Our Ref: BR/27/20/DOC

Approval of details reserved by condition imposed under ref BR/63/19/PL relating to Condition Nos 3 - dustbin storage, 5 - renewable energy, 7 - material & finishes, 10 - Construction Management Plan, 13 - cycle parking spaces, 15 - visibility splays and 16 - pedestrian visibility splays

15-17 Kew Gardens Bognor Regis PO21 5RD

Condition Number 15

Project:-	
Proposed Residential Development 15-17 Kew Gardens Bognor Regis West Sussex	
Title:-	
Proposed Visibility Plan (Plots 1,2&3)	
Client:-	
Imperial Homes (Southern) Ltd	
Scale:-	
1:100 (@A1)	
Drawn By:-	Checked By:-
PJD	
Date:-	Date:-
02/03/20	
Job.No:-	Drg.No:-
180037	16
	Rev:-

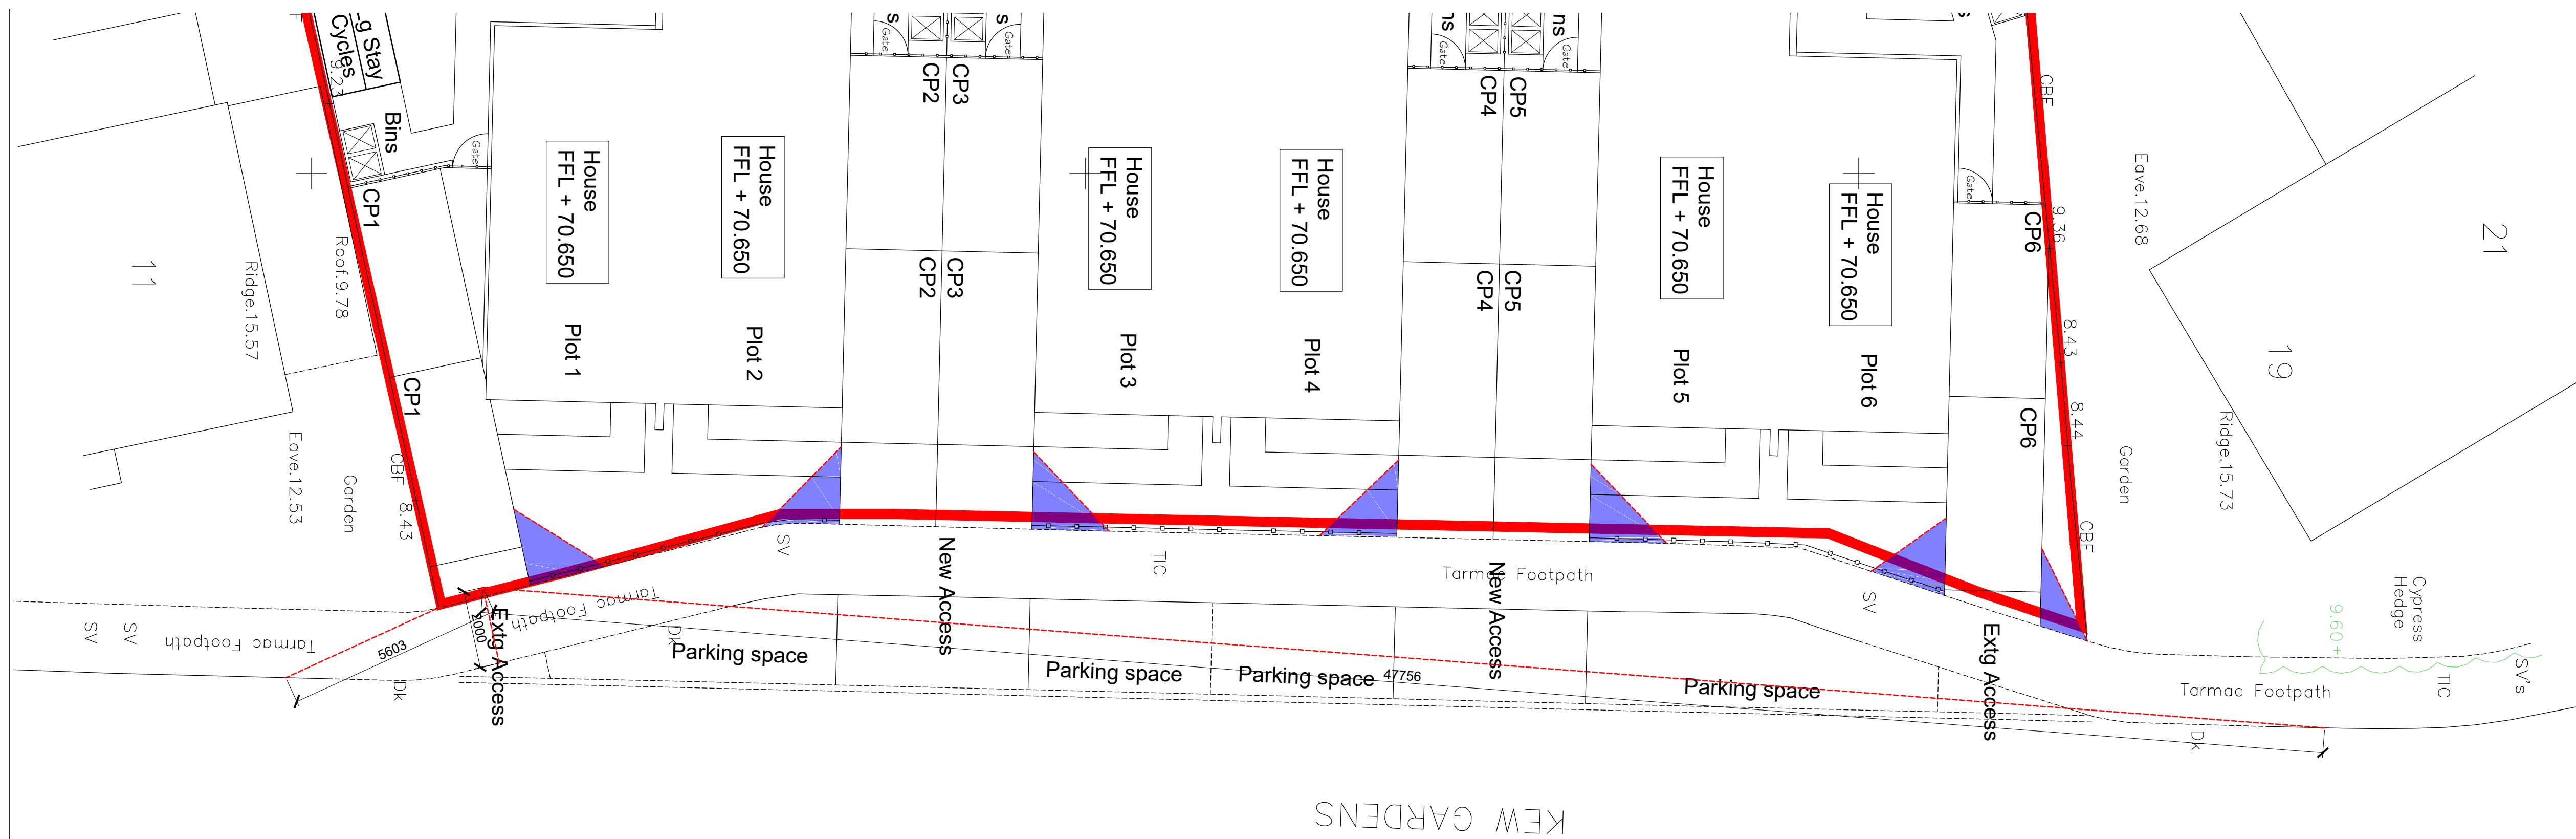
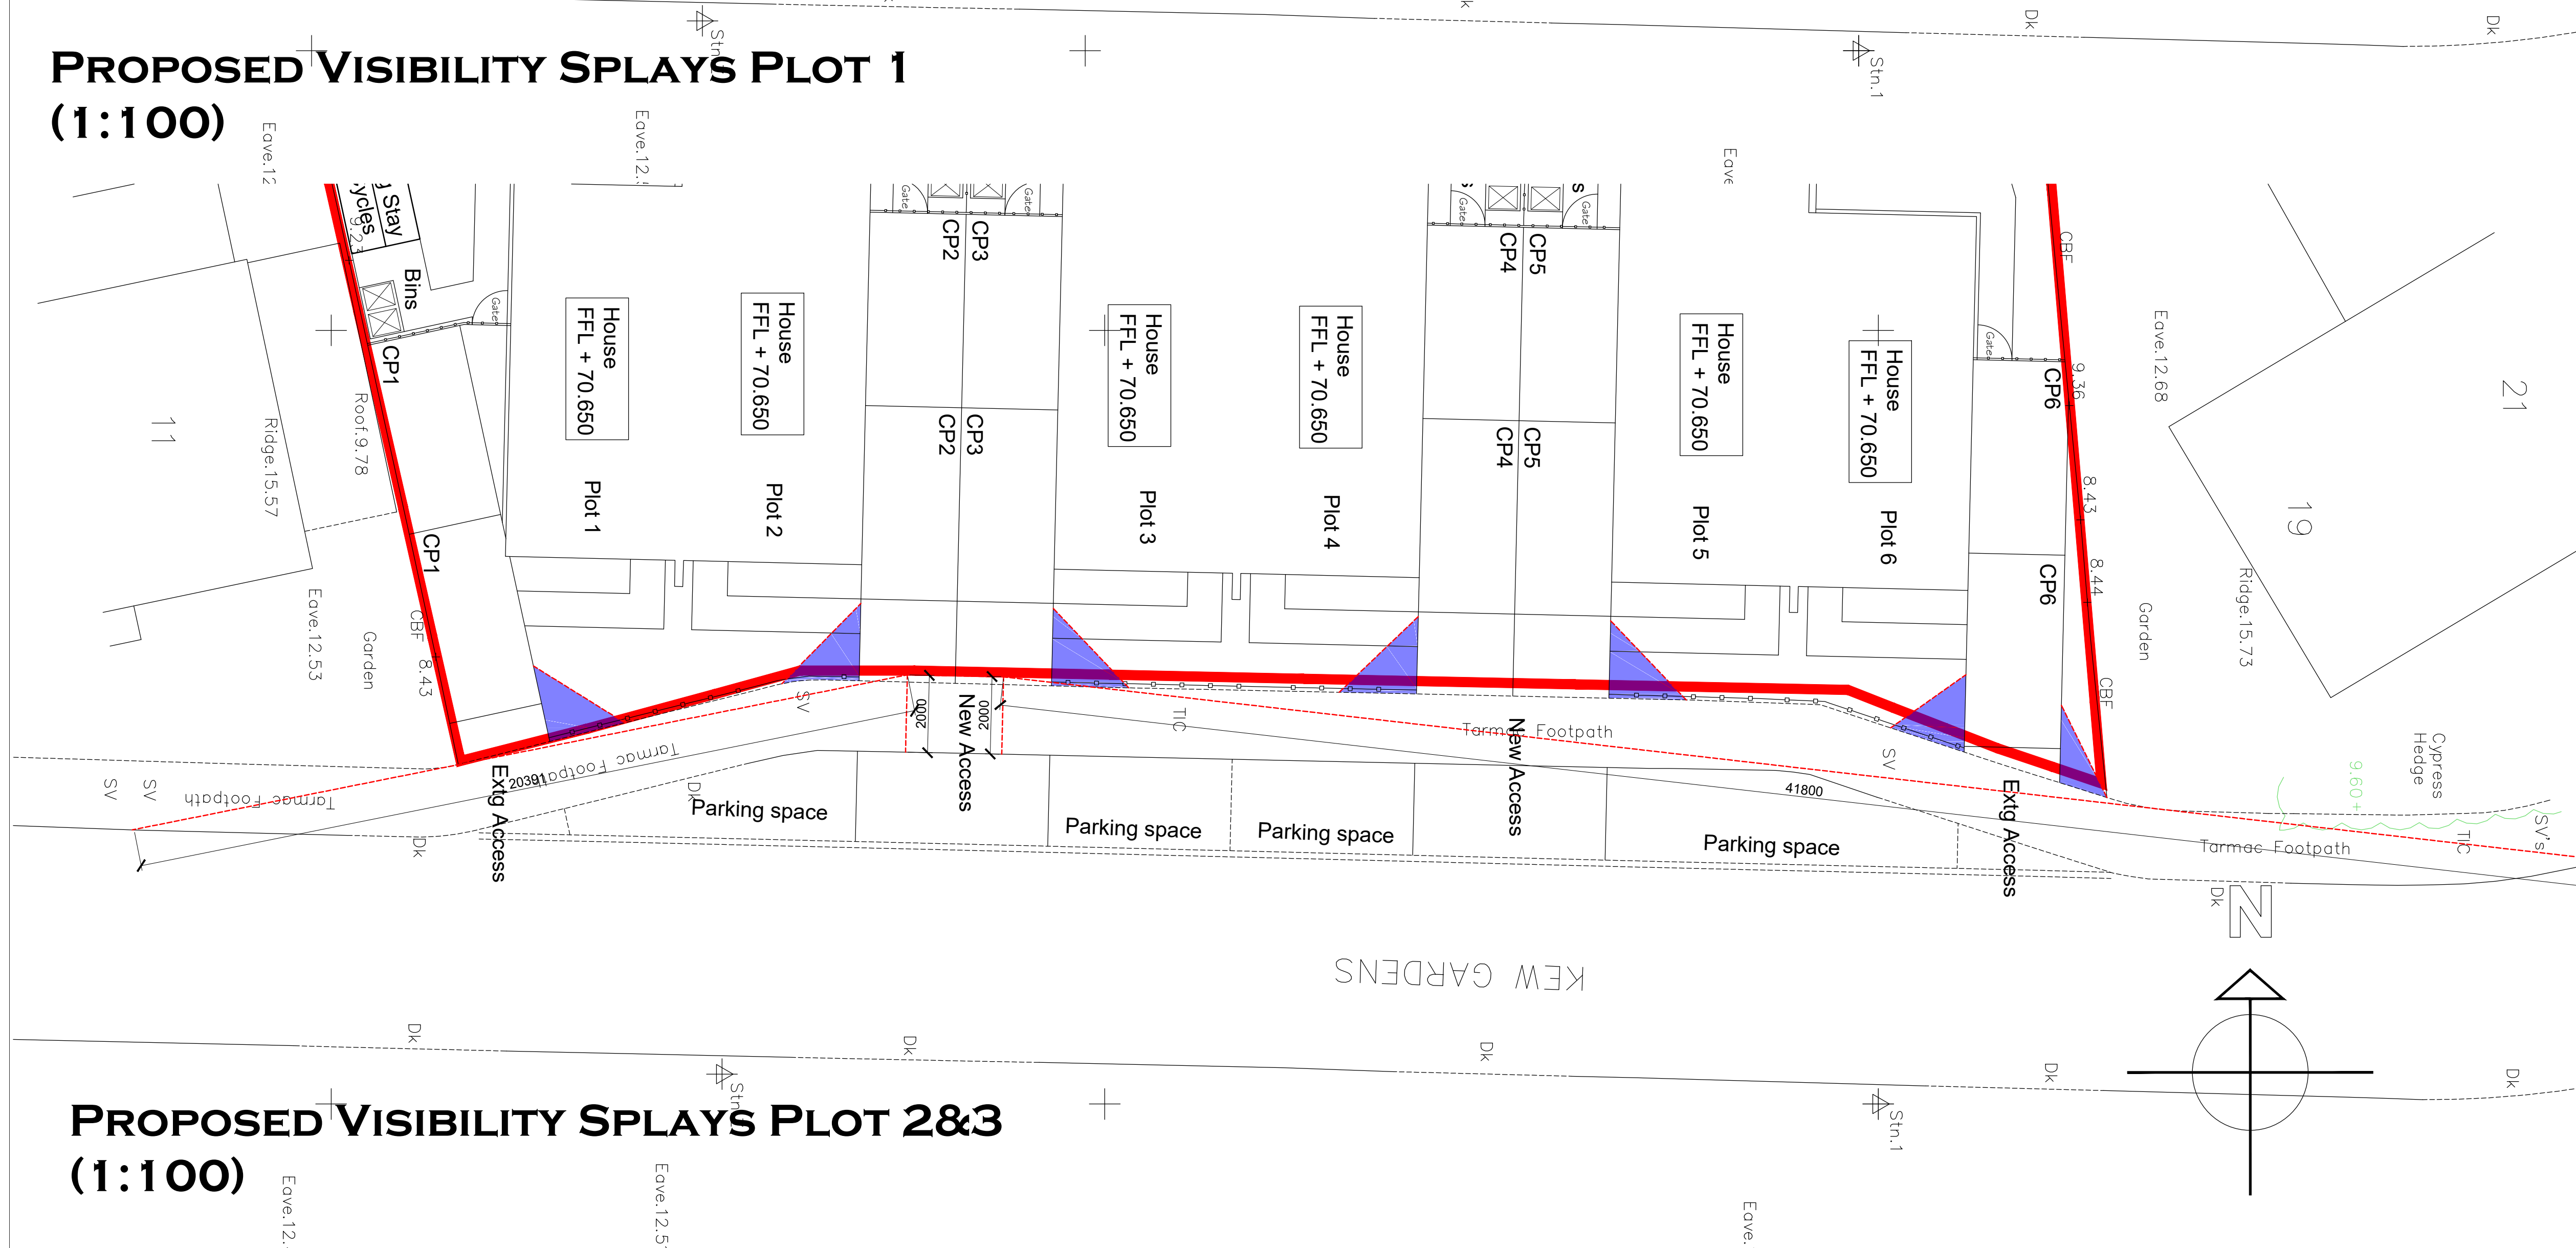
West Sussex County Council Highways have been consulted and commented submitted drawings: 'Maximum achievable vehicular visibility splays have now been demonstrated from each access point to the public highway. Whilst some of these splays pass through lay-by Manual for Streets 2 paragraph 10.7.1 states that Parking in visibility splays in built-up areas is quite common, yet it does not appear to create significant problems in practice. Ideally, defined parking bays should be provided outside the visibility splay. However, in some circumstances, where speeds are low, some encroachment may be acceptable. The LHA consider that Kew Gardens is low speed and lightly trafficked and therefore the splays demonstrated are acceptable and plans and details pertaining to condition 15 are acceptable.'

Drawing No.16, Proposed Visibility Plan, Plots 1,2 & 3 received on 06/04/2020 and
Drawing No. 17, Proposed Visibility Plan, Plots 4,5 & 6 received on 06/04/2020

Therefore, the condition is fully discharged insofar as the submission of details relates and on the understanding that the splays demonstrated will be permanently retained.
